LAND WEST OF PAGHAM ROAD
PAGHAM
WEST SUSSEX
STAGE 1 ROAD SAFETY AUDIT

Designer's Response

J NY10700-03a
Designer's Response
Version 03a
05 January 2022

LAND WEST OF HOOK LANE, PAGHAM, WEST SUSSEX
PROPOSED ACCESS ARRANGEMENT
STAGE 1 ROAD SAFETY AUDIT

RPS Drawing/Figure Number JNY10700-01 Rev D

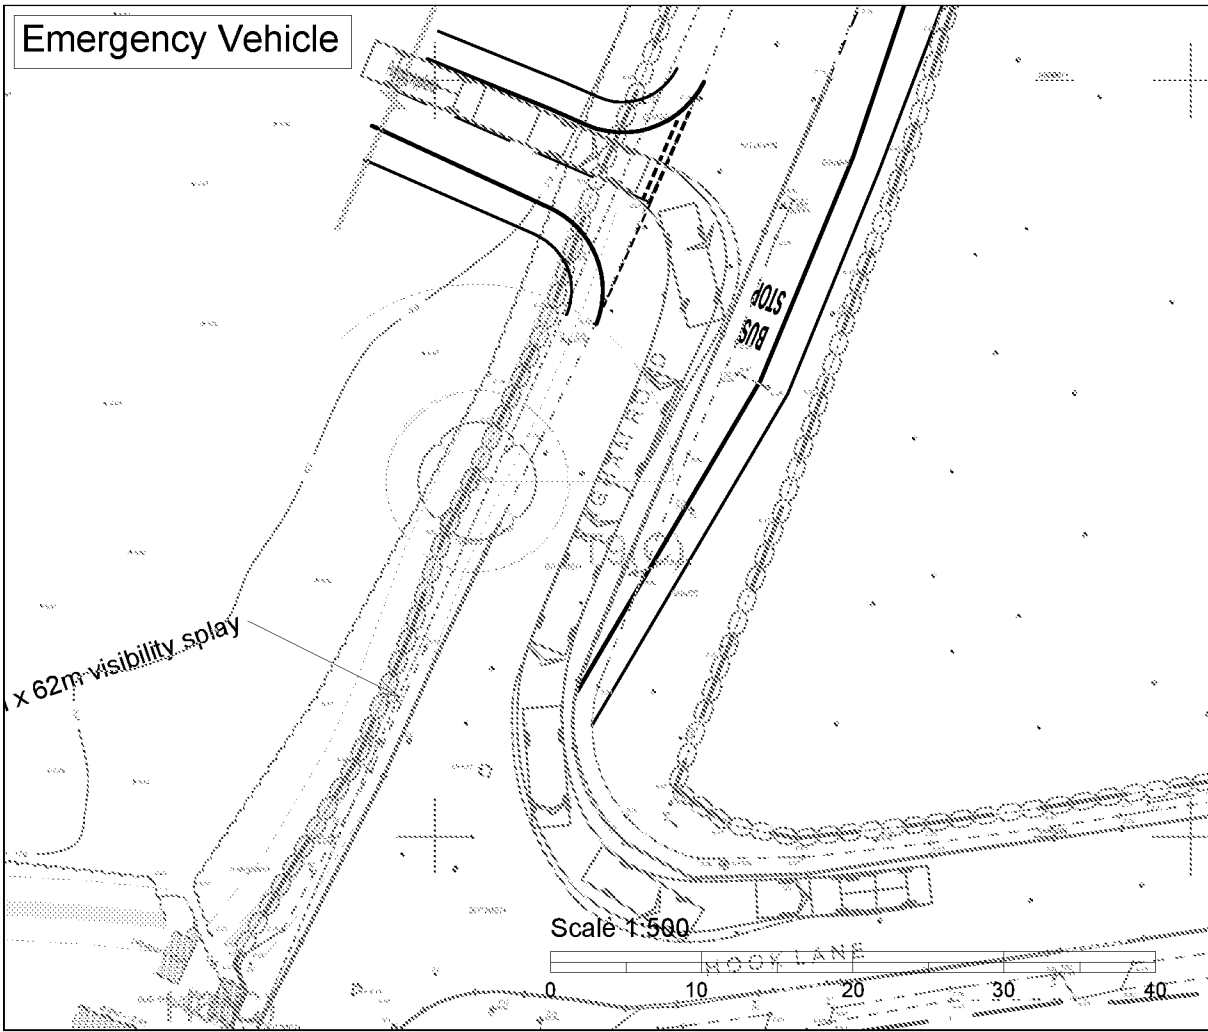
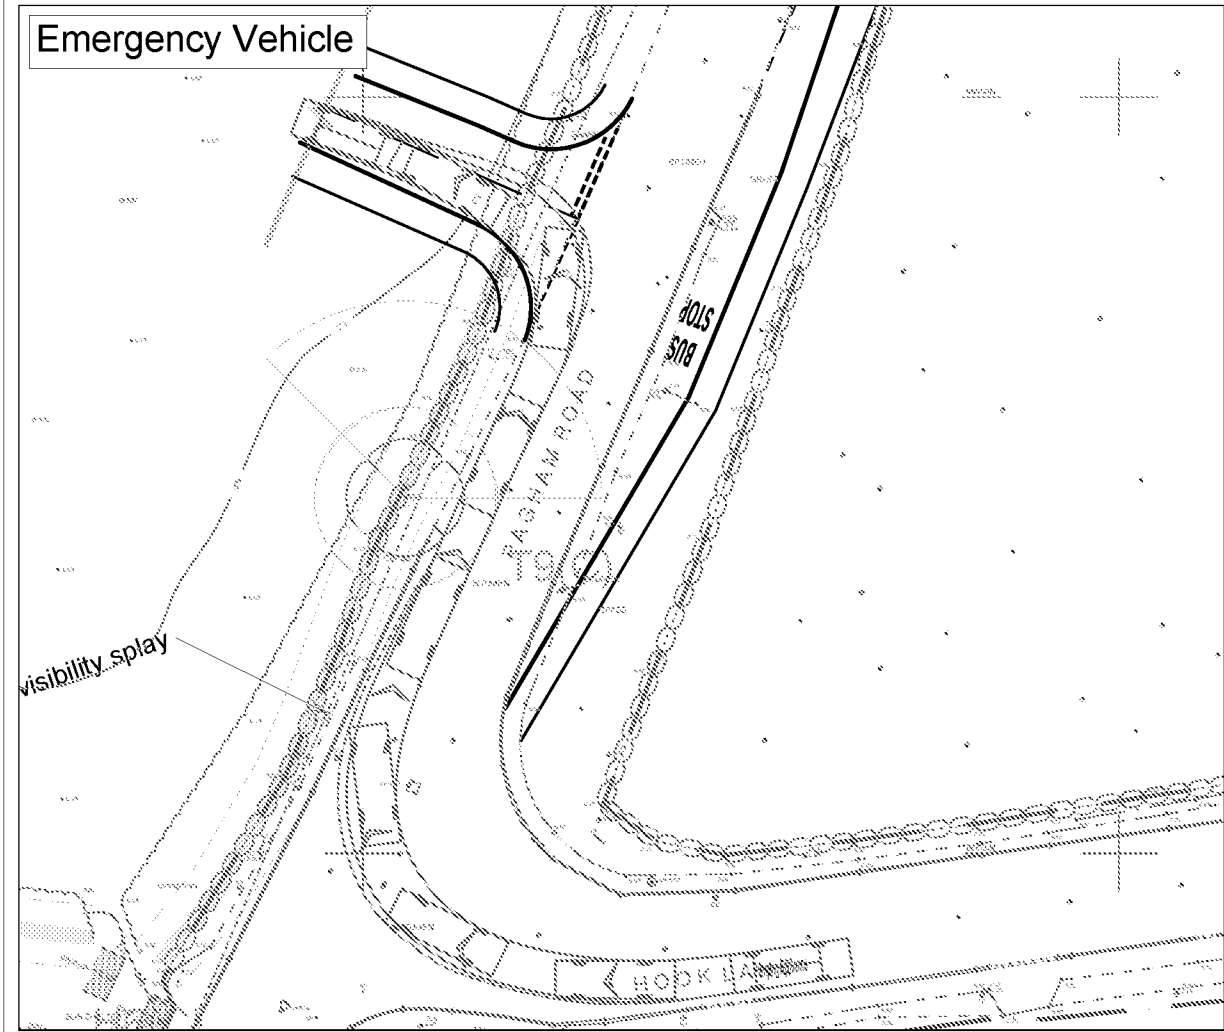
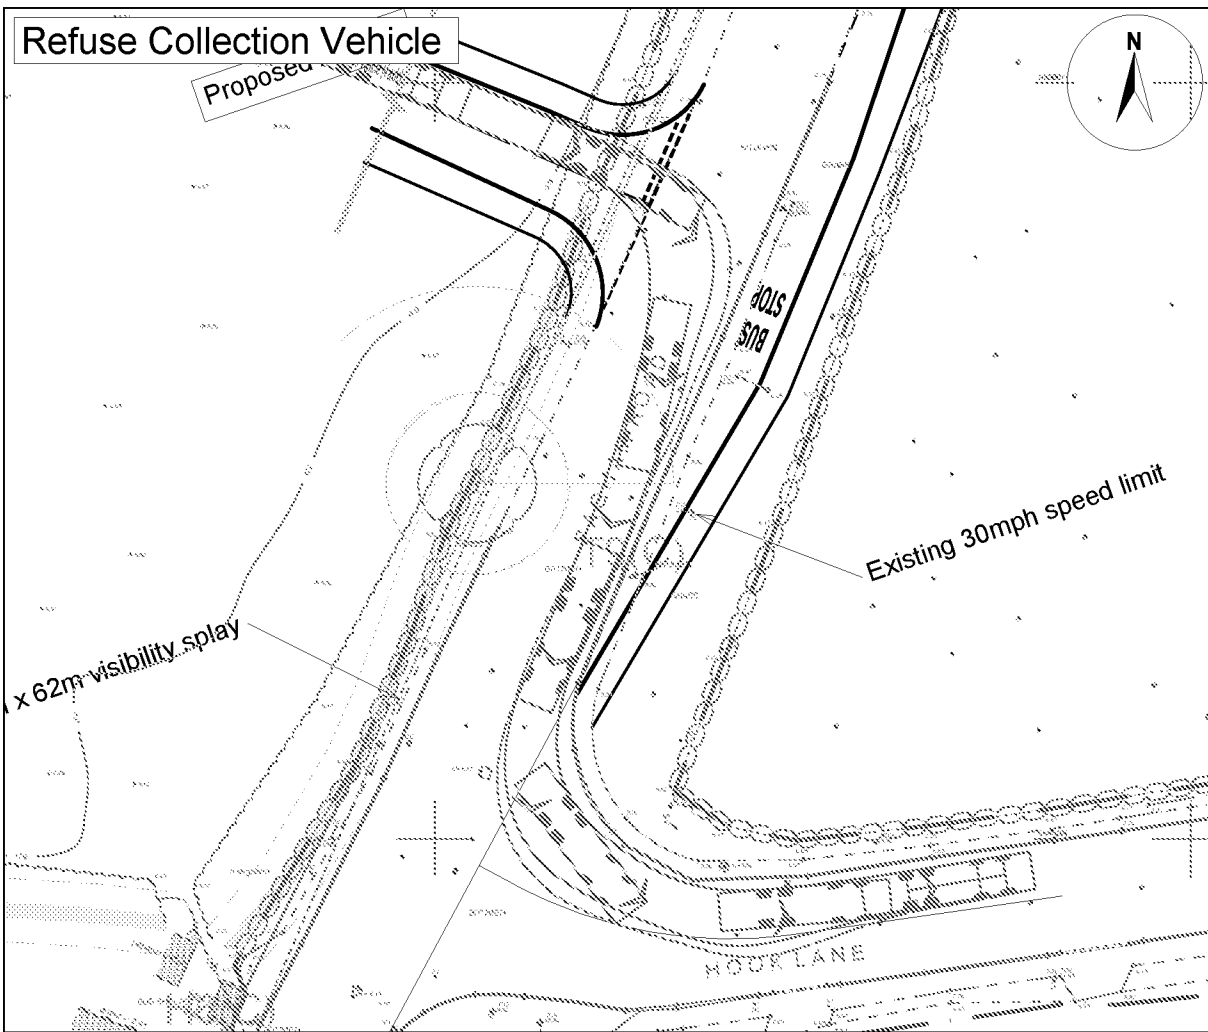
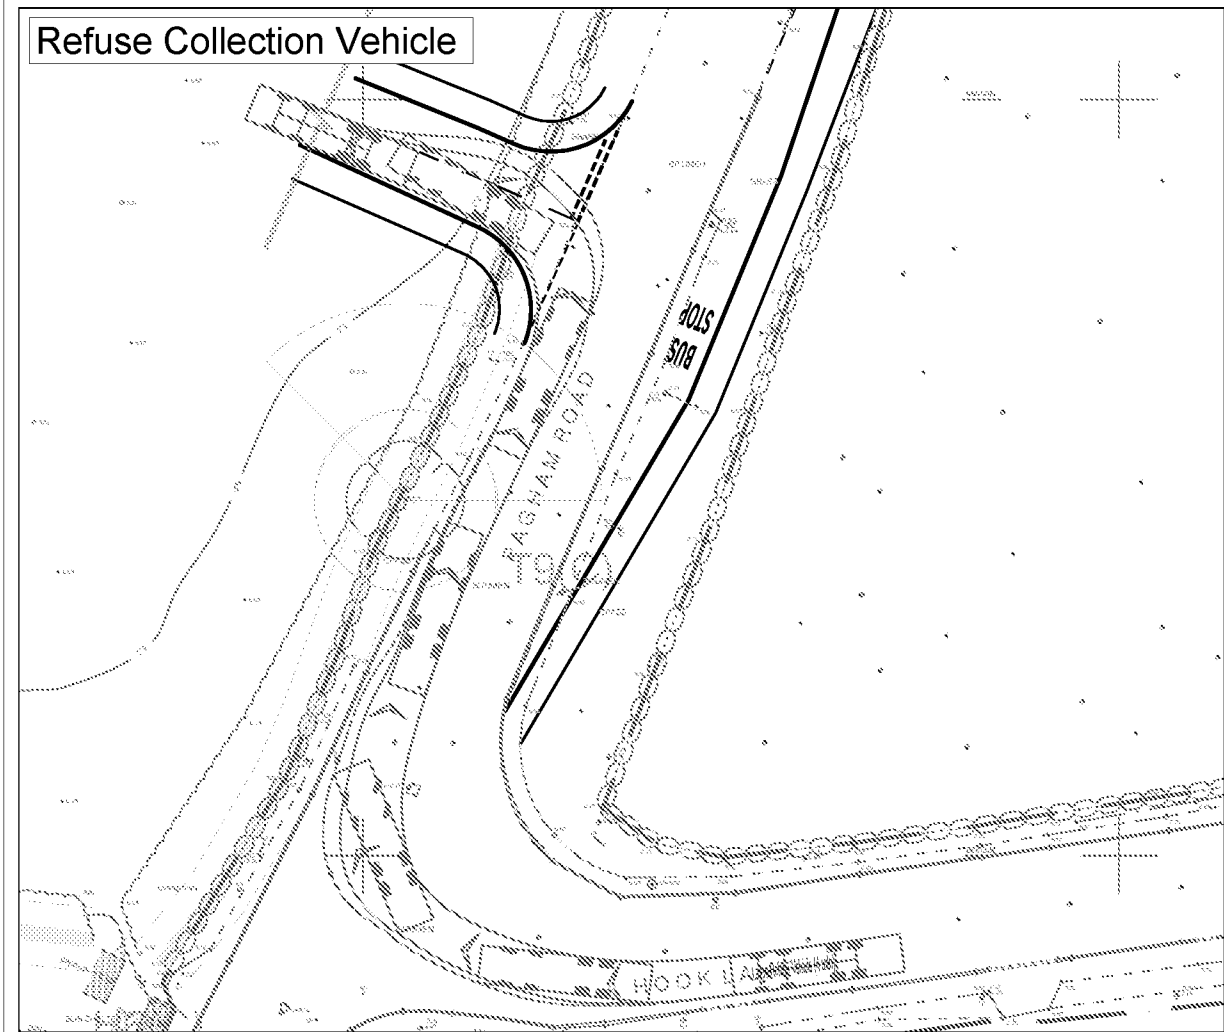
Location Proposed development access (Drwg No. J NY10700-01 Rev D)

Summary Lack of pedestrian provision may result in pedestrian to vehicle type collisions

The drawing indicates that a new development access junction is proposed on the western side of Pagham Road.

Dropped kerbs and tactile paving are not shown on either the northern or southern side of the junction. This may increase the risk of pedestrian trip hazards and / or vehicle to pedestrian type collisions.

The Audit Team recommend that appropriate dropped kerbs and tactile paving are provided.

- 2.1 The above recommendation is accepted. The provision of dropped kerbs and tactile paving will be investigated at the detailed design stage and reviewed as part of the Stage 2 Road Safety Audit once the detailed design has been completed.
